THIRU PAVAN RAINA, I.A.S.,
Member -Secretary,
Madras Metropolitan
Development Authority,
No.8, Gandhi-Irwin Road,
Madras-600 008.

A2/27078/91

30.1.92

Sub: MMDA - Planning Permission - Construction
of residential building in Plot No.24-2 at
S.No.99/20 of Kolathur village - Approved
regarding.

SITE PLAN

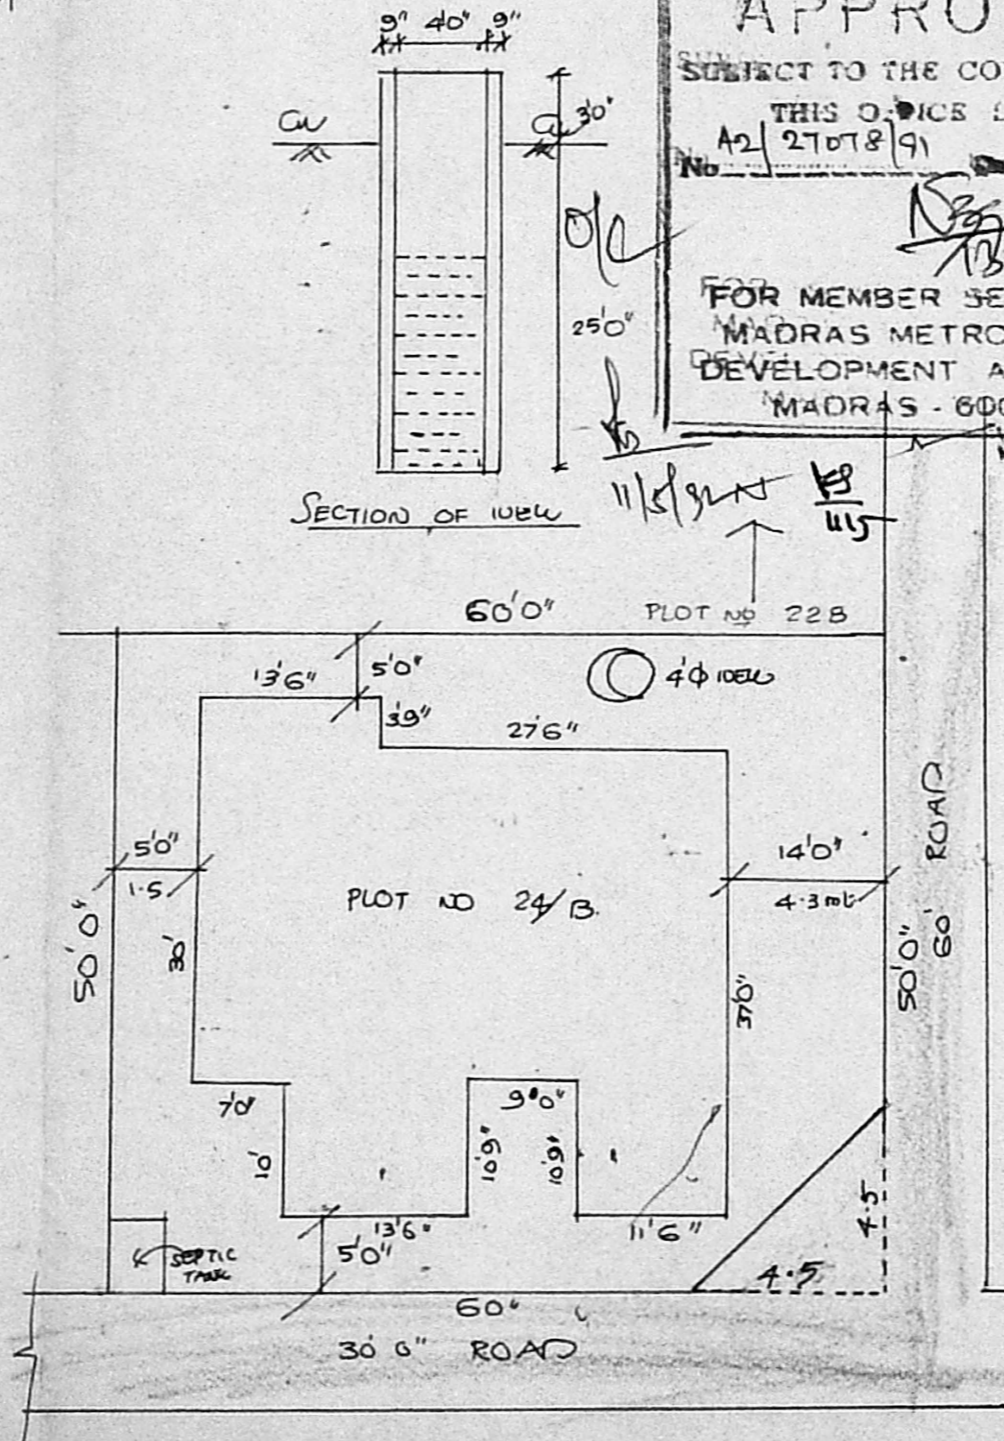
You are also requested to
furnish affidavit and indemnity bonds duly notarised and also
revised plan showing splay as 4.50m x 4.50 m and front set back
4.50m on eastern side.
